20240723-ABP-319612

Ref: ABP-319612-24

App: Scotshouse Quarries

For: Application for Prospective Development Consent by Scotshouse Quarries, Aghnaskew, Scotshouse, Co. Monaghan under Section 37L to be assessed in parallel with Section 177E Substitute Consent Application (ABP-316144-23). The development concerns an extension of Scotshouse Quarry (per Planning Reference 83/09) and the site covers an area of 14.6 hectares.

Figure 8-1: Hydrological Connection and Discharge Points

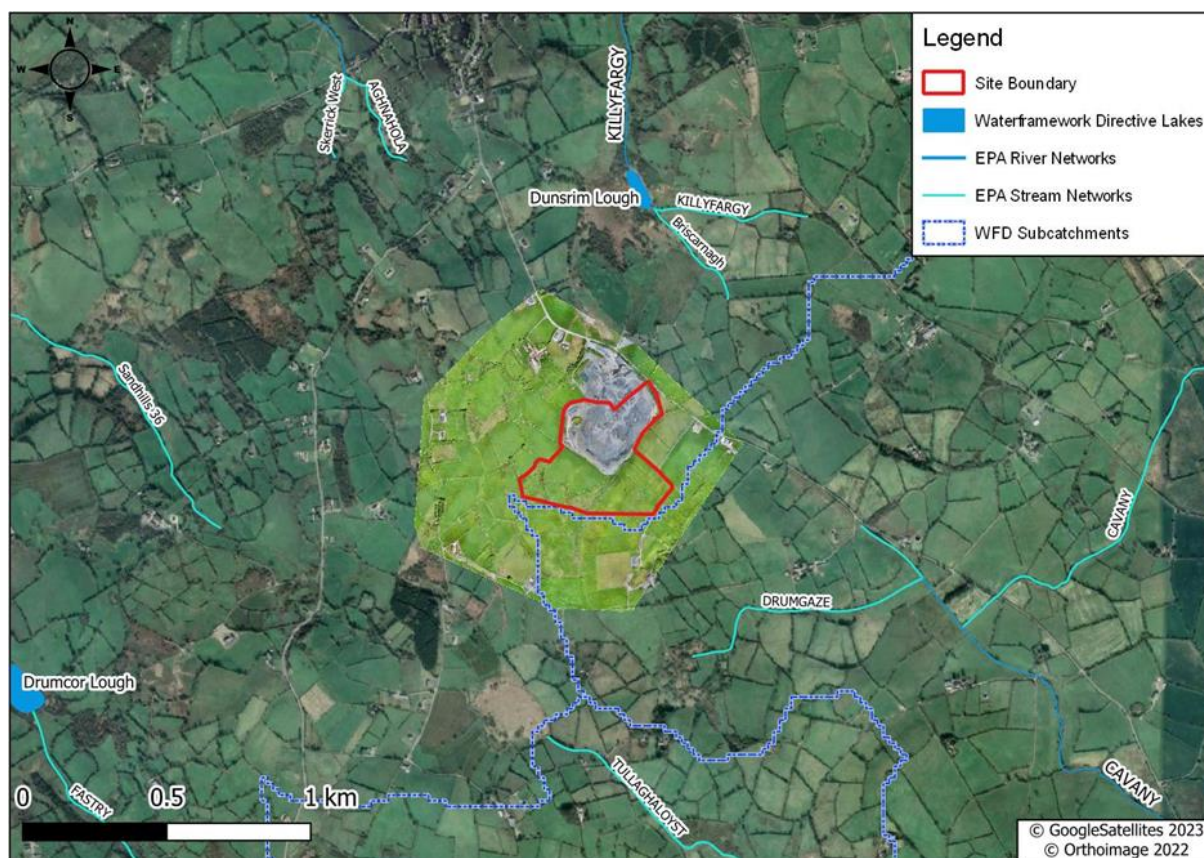
We note that a Trade Effluent Discharge Licence was granted by Monaghan County Council under ref. 14/124. This is collected and held within a pit containing 4 x linked settlement tanks. Water goes through the four tanks before discharging at the southeast of the site via a hydrocarbon class interceptor. Then it flows via a pipe to an open roadside drain which flows to the northwest through agricultural land before discharging to a wetland area downstream of Dunsrim Lough.

We submit that there is a need to give close consideration to the quality of the effluent which discharges downstream of Dunsrim Lough. This discharge could act as a potential pathway for suspended solids from on-site activities to enter into the connected drainage network which joins the Gortnana river for example. This is particularly important given that the Gortnana river, which is hydrologically connected to the Lough, is at risk of not achieving good water quality status under the WFD by 2027. It appears to be a wetland area of ecological value with shrubs visible via satellite imagery and the presence of cut over raised peat which is a wetland indicating sediment, as identified by a Wetlands Survey Ireland map¹. These could be indicators of flora and fauna ecological receptors which are likely to contain birds and plants.
